**WELWYN HATFIELD COUNCIL – DEVELOPMENT CONTROL**  
**DELEGATED REPORT**

<b>APPLICATION No:</b>	<b>N6/2012/0692/FP</b>
<b>APPLICATION Site:</b>	<b>6 Fordwich Road, Welwyn Garden City</b>

The proposal is a full planning application for the erection of a single storey side and rear extension. This will provide a (4<sup>th</sup>) bedroom, shower room and Utility Room to the side of the dwelling; and, a dining room across the full-width of the rear elevation.

**DRAWING TITLE**  
PROPOSED SINGLE STOREY SIDE  
AND REAR EXTENSIONS

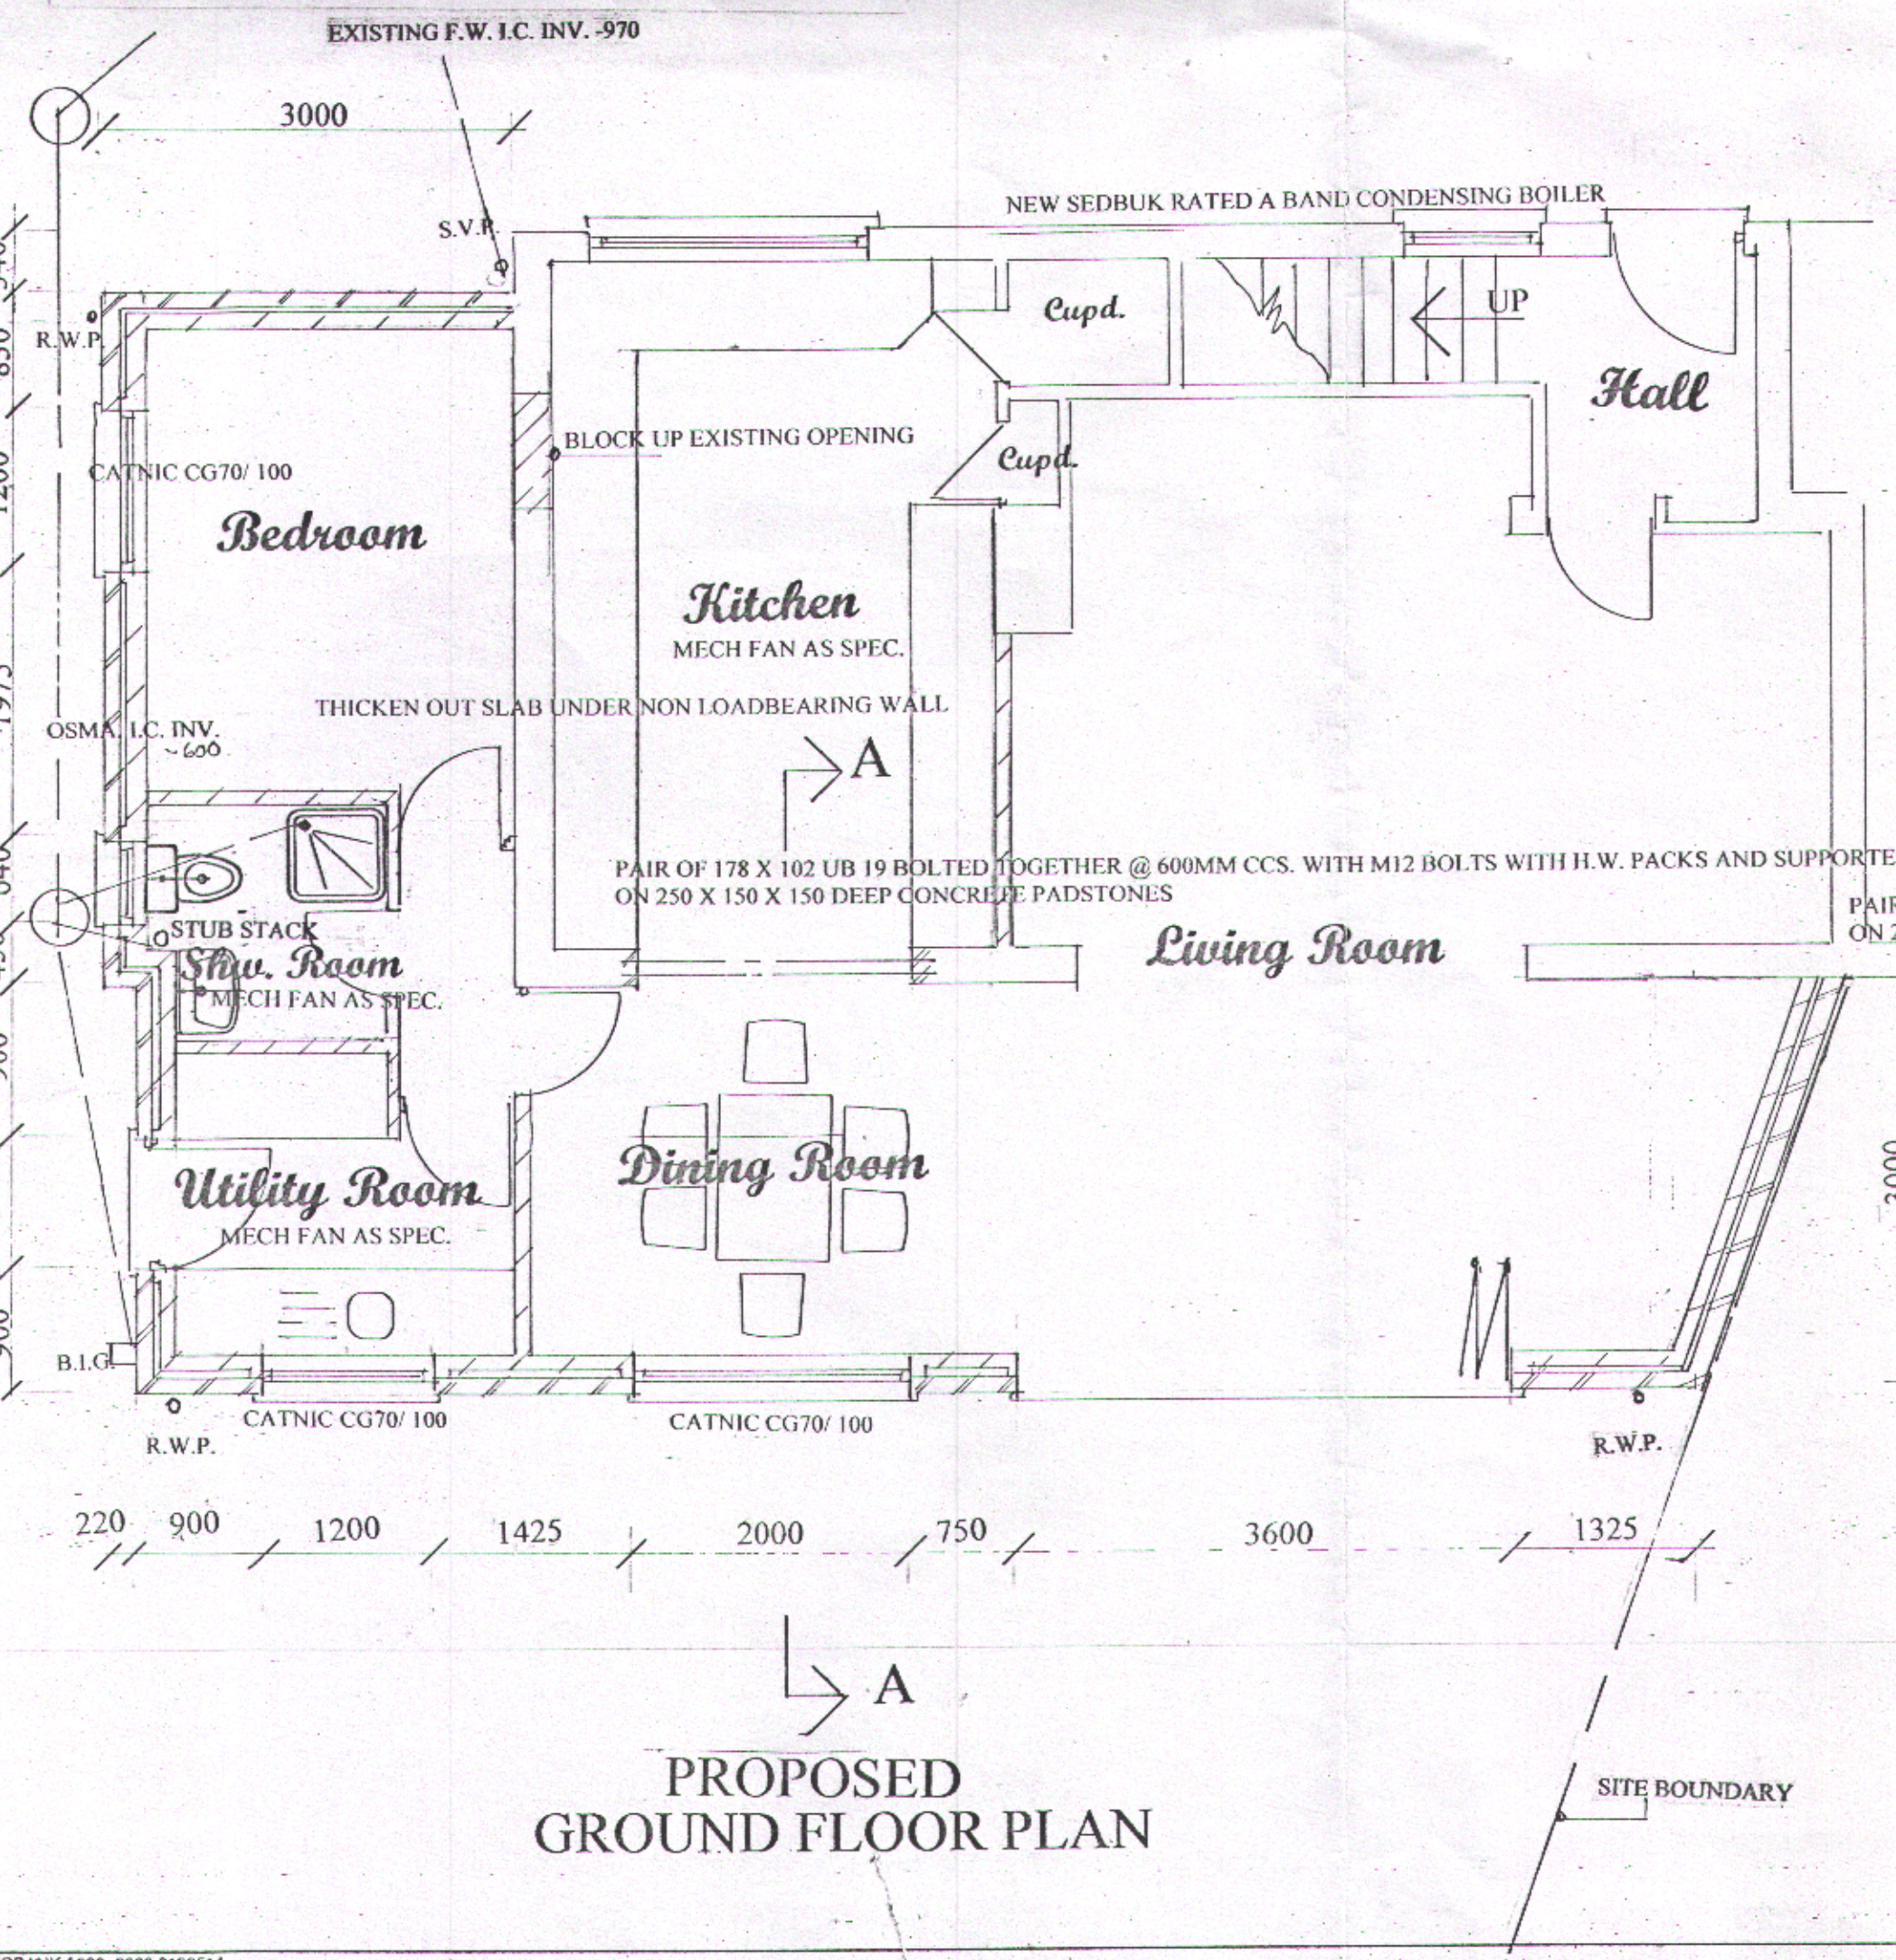
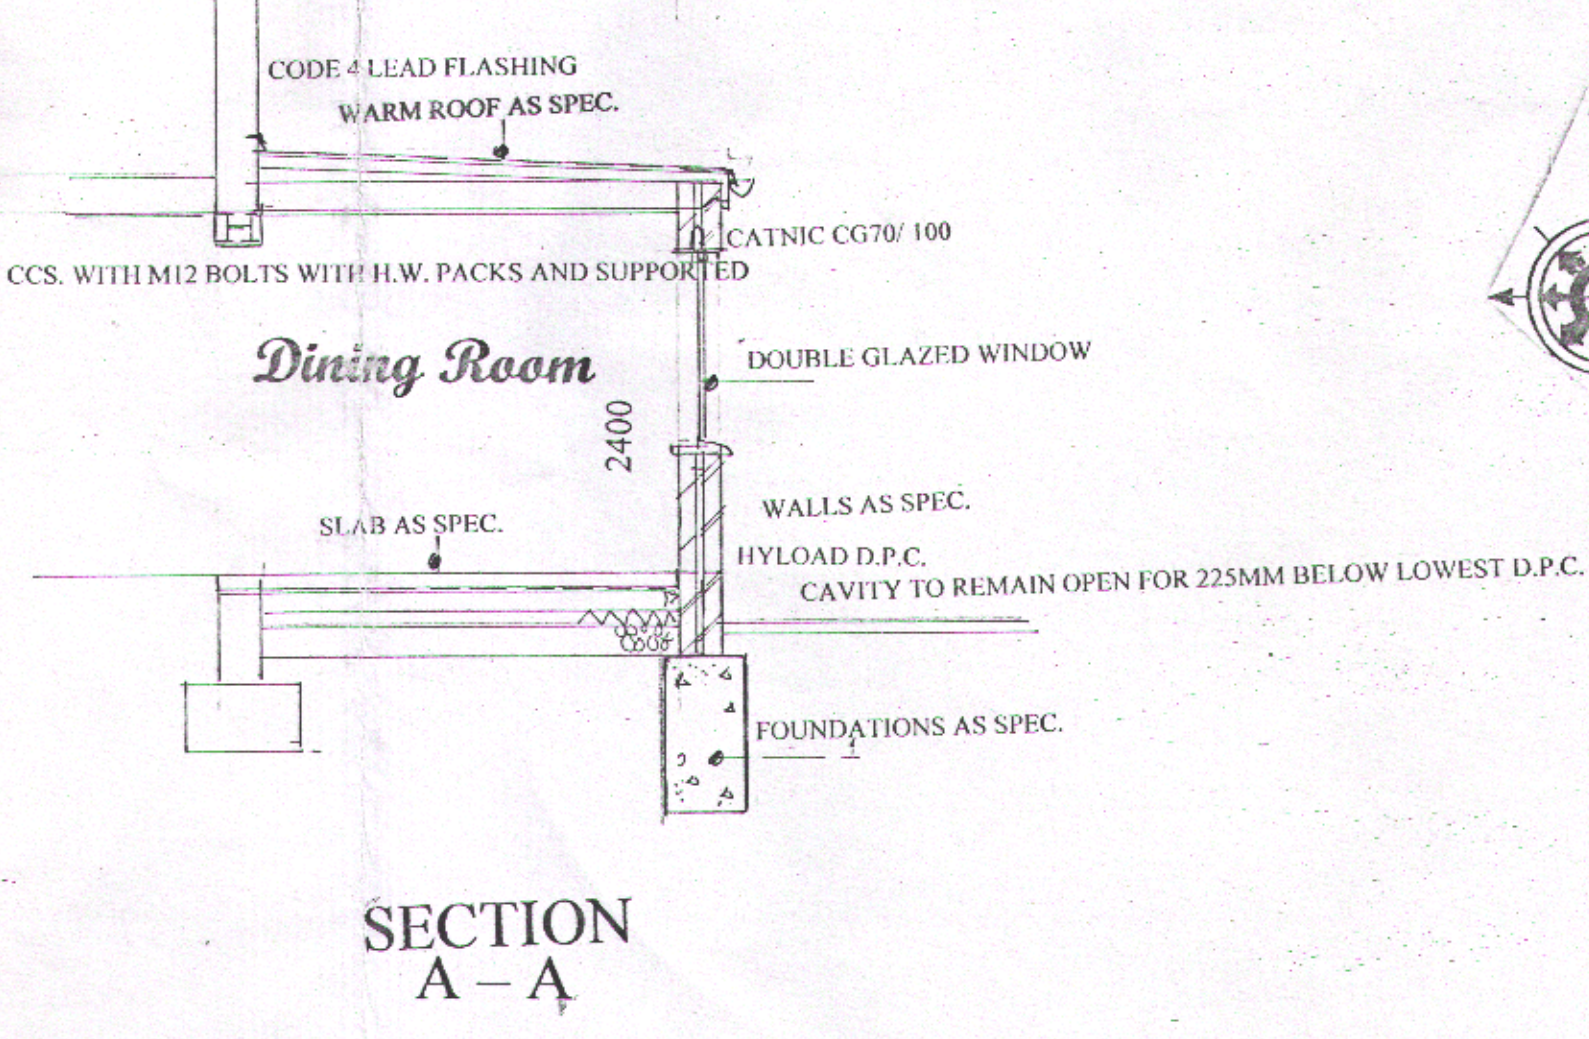
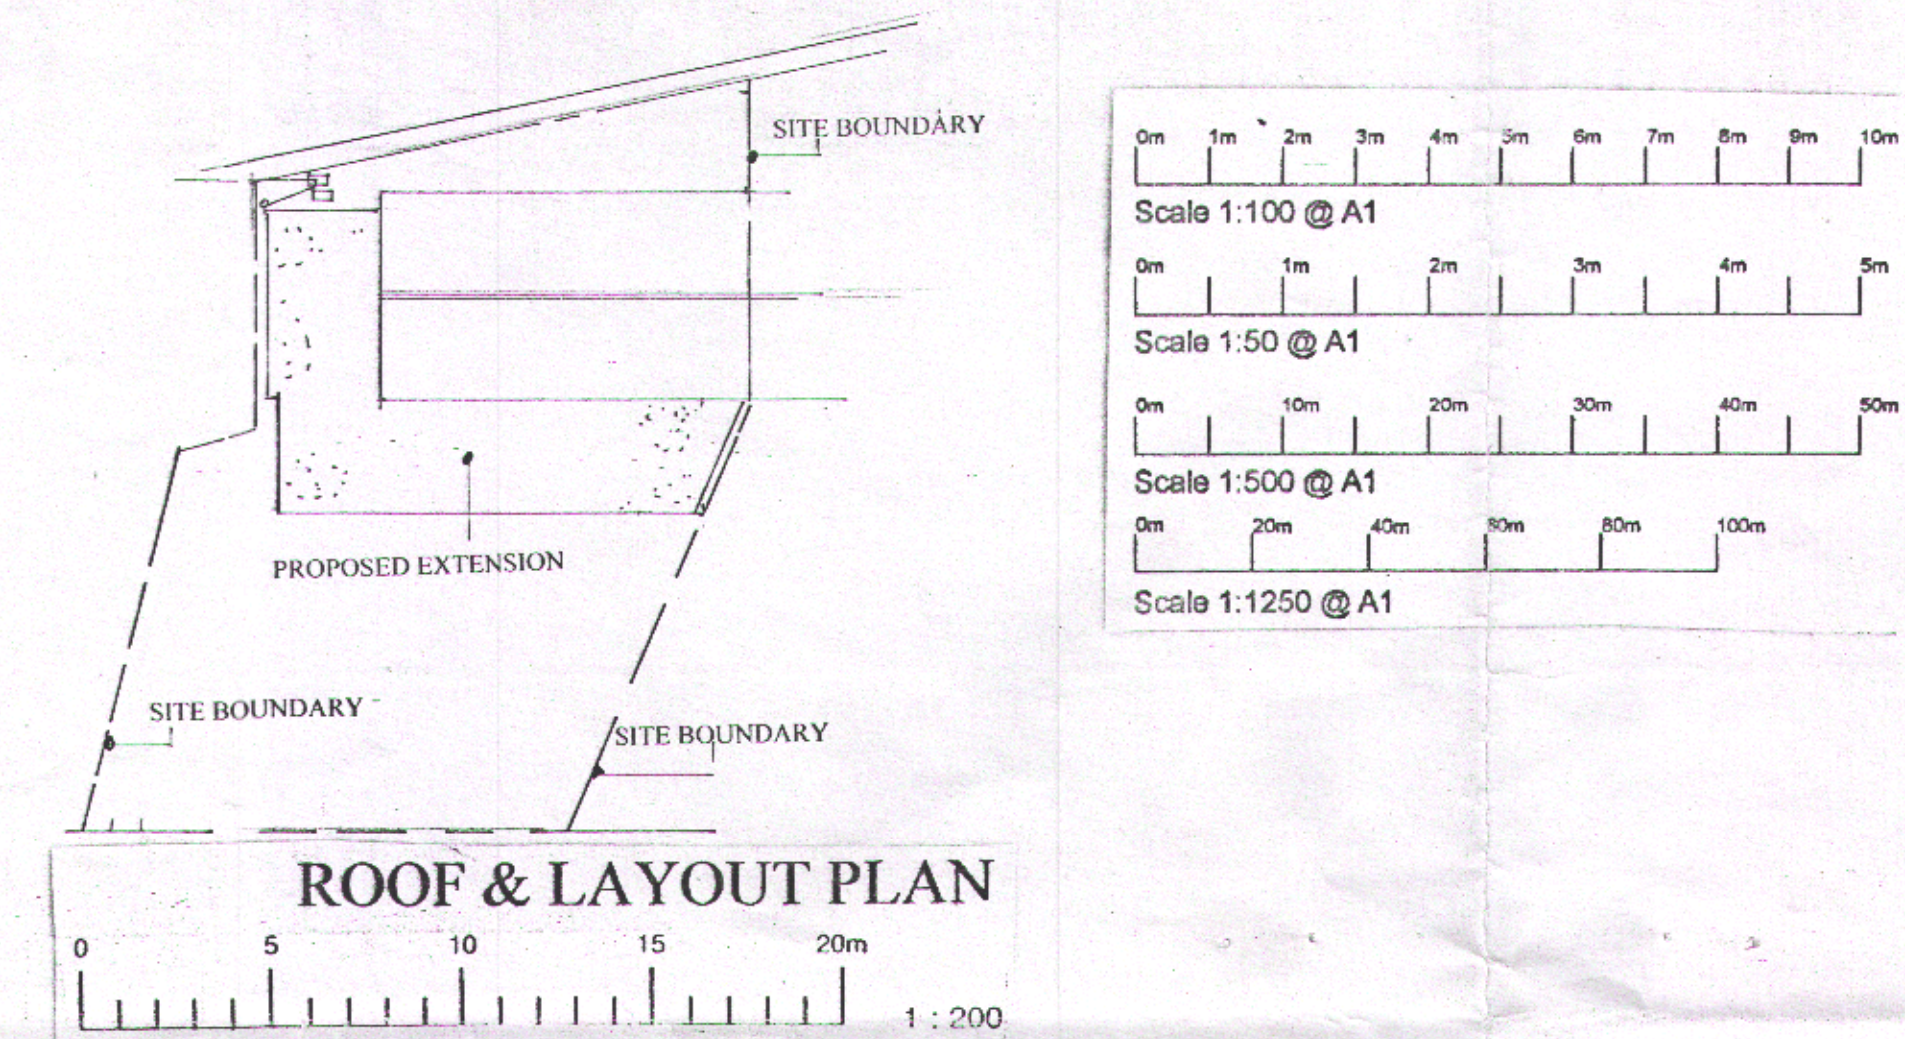
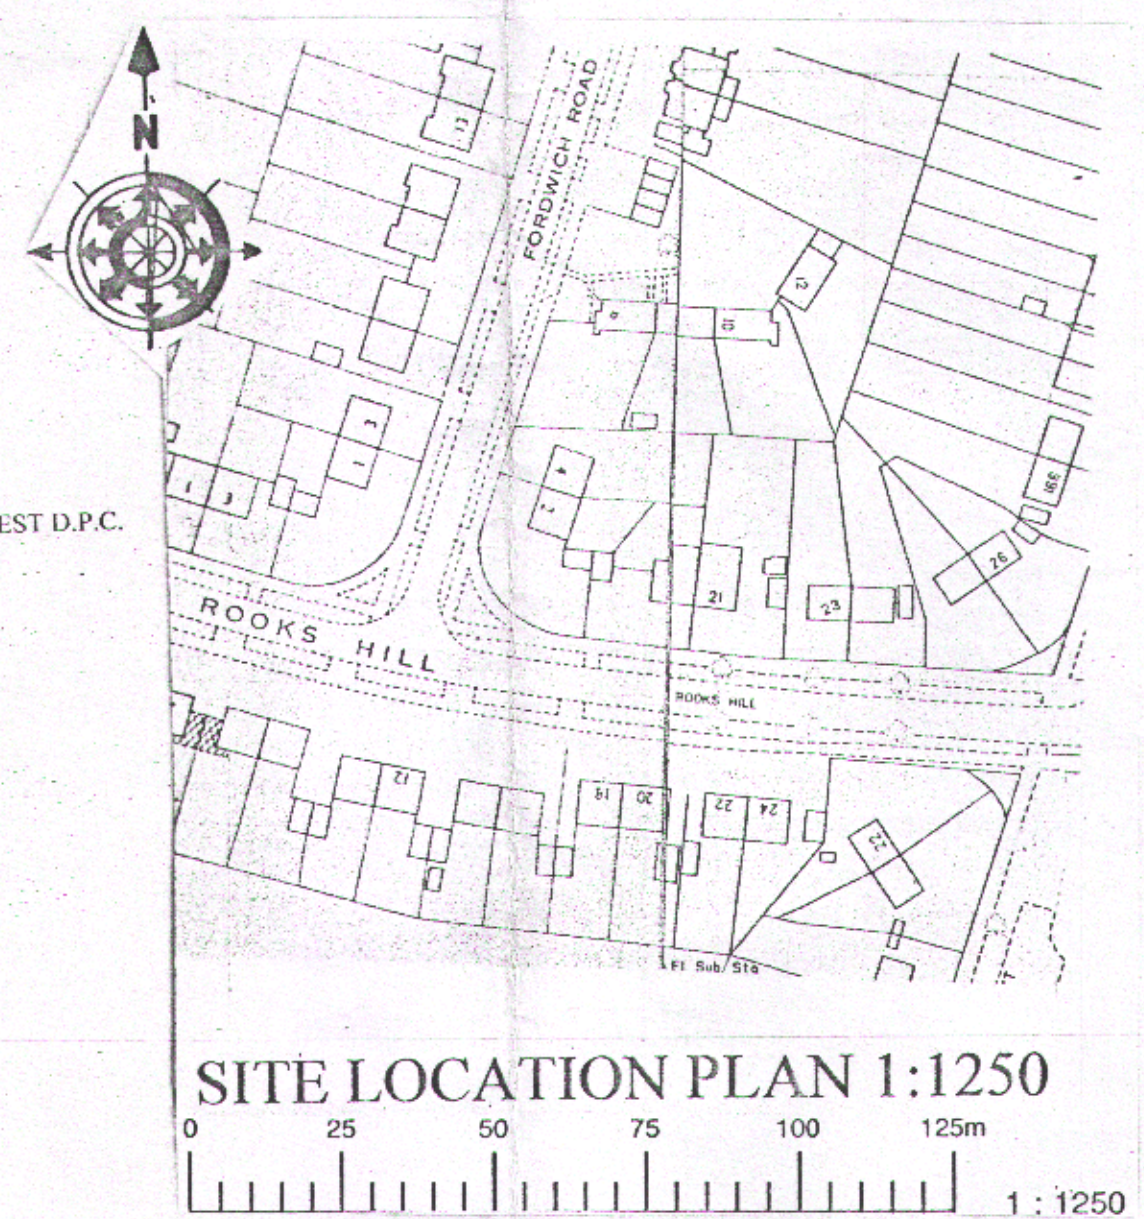
The proposed extensions follow a refusal in 2006. The current extensions are in fact, larger than the previous refusal due to the single storey rear extensions, although the side extension has been reduced in width by 1m. The form of the extension is similar to many single storey extensions on the side of end of terrace dwellings within the town. Although larger, the rear extension is not an issue because it would be screened by a large 1.8m Beech hedge that exists on the side boundary. Therefore the most prominent section would be the side extension when viewed from the north and immediately to side of the site. There is an existing single storey side section but this is only c.1m wide. The extension would be screened by an existing tree and shrubbery on the open frontage area to the north but part of the extension would be prominent. The applicant has offered to plant a Beech Hedge to mitigate the impact built this would not necessarily serve any useful purpose as the side windows in the extension would mean it would never grow more than 1.2m. However, some landscaping would be beneficial in terms of reducing the impact.

The reduction in width of the extension and the slight reduction in height would reduce the impact, albeit that a single storey side addition has also been added. However, given the location of the Beech hedge to the side, the fact that this would be retained save a small section to allow for the construction of the extension means that the proposal would not be so harmful to the conservation area, subject to additional landscaping is also being proposed that it should be refused on these grounds alone.

The extensions are proposed to be sited to the side and rear of the existing dwelling, and are single storey. The attached adjoining dwelling at No. 8 Fordwich Road shares an angled boundary with No. 6. The proposed rear dining room extension would be 3.0m deep; however, it would be site at an angle away from No. 8 and as such would have a minimal impact on the amenities of occupants of this adjoining dwelling through any loss of light or outlook. No windows are proposed to be inserted in the extension that would face this neighbouring dwelling.

4. No development shall take place until full details on a suitably scaled plan of soft landscape works have been submitted to and approved in writing by the Local Planning Authority. The development shall not be carried out other than in accordance with the approved details unless otherwise agreed in writing by the local planning authority. The landscaping details to be submitted shall include:-
